MOUNT THORLEY OPERATIONS 2014 PROJECT – SSD 6465

Reference is made to your email to the Environment Protection Authority (EPA), dated 24 June 2014, seeking comments on the Mount Thorley Operations 2014 (the project) development application, reference SSD 6465, which is applied for by Mt Thorley Operations Pty Limited under Part 4 of the *Environmental Planning and Assessment Act 1979* (EP&A Act).

The EPA has reviewed the project as detailed in the report titled '*Mount Thorley Operations 2014 – Environmental Impact Statement: 15 June 2014*' (EIS), Volumes 1 – 5, prepared by EMGA Mitchell McLennan.

Figure 6.3 Proposed Water Management System Schematic

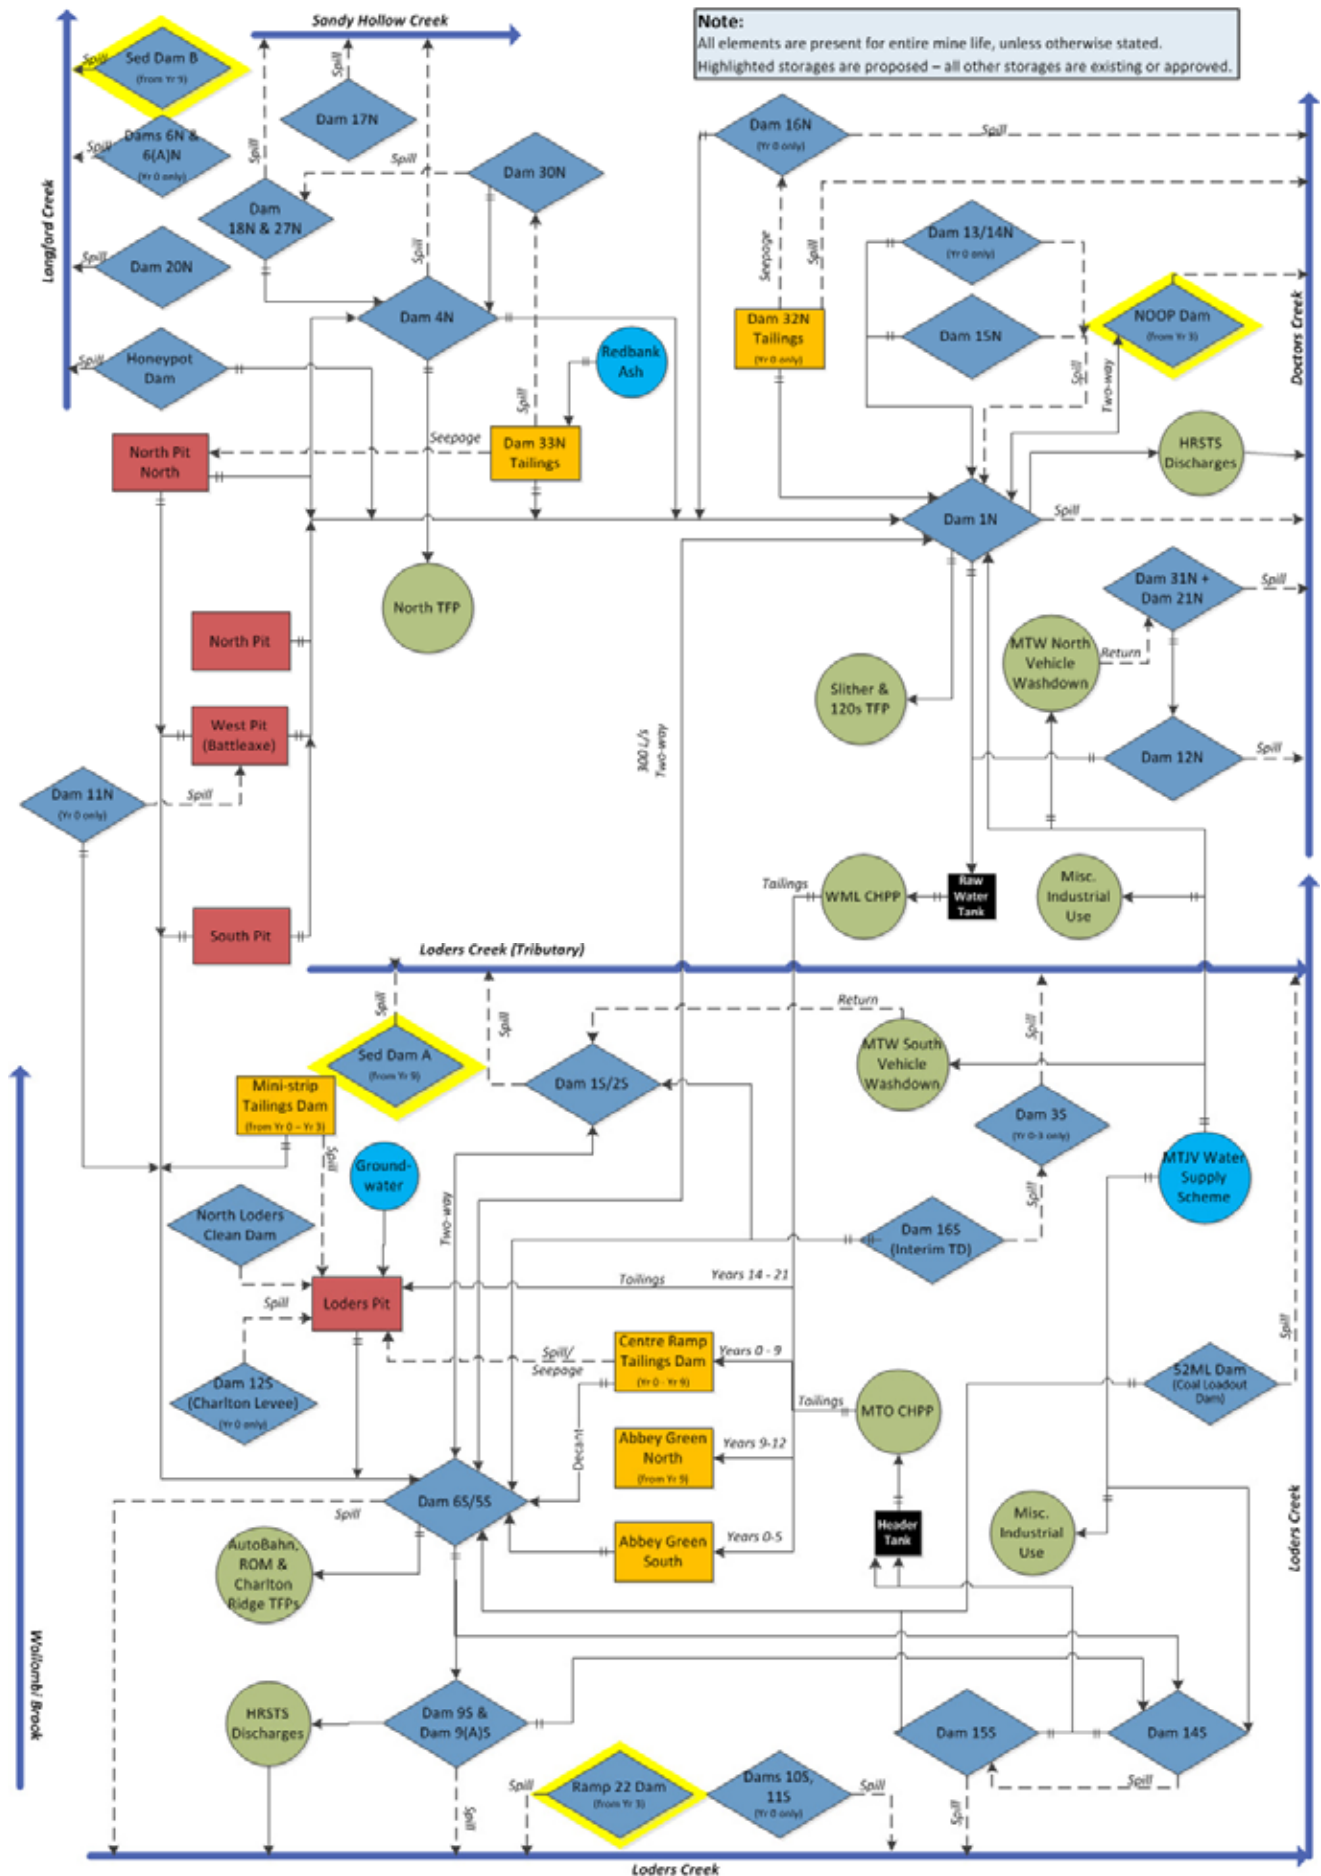
Appendix J identifies the dam overflow receiving environments in Table 6.3. E.g. node number 106 'Dam 6S (SOOP Dam)' overflows to Loders Creek, however the EPA is concerned about the lack of information on the predicted frequencies of these occurring.
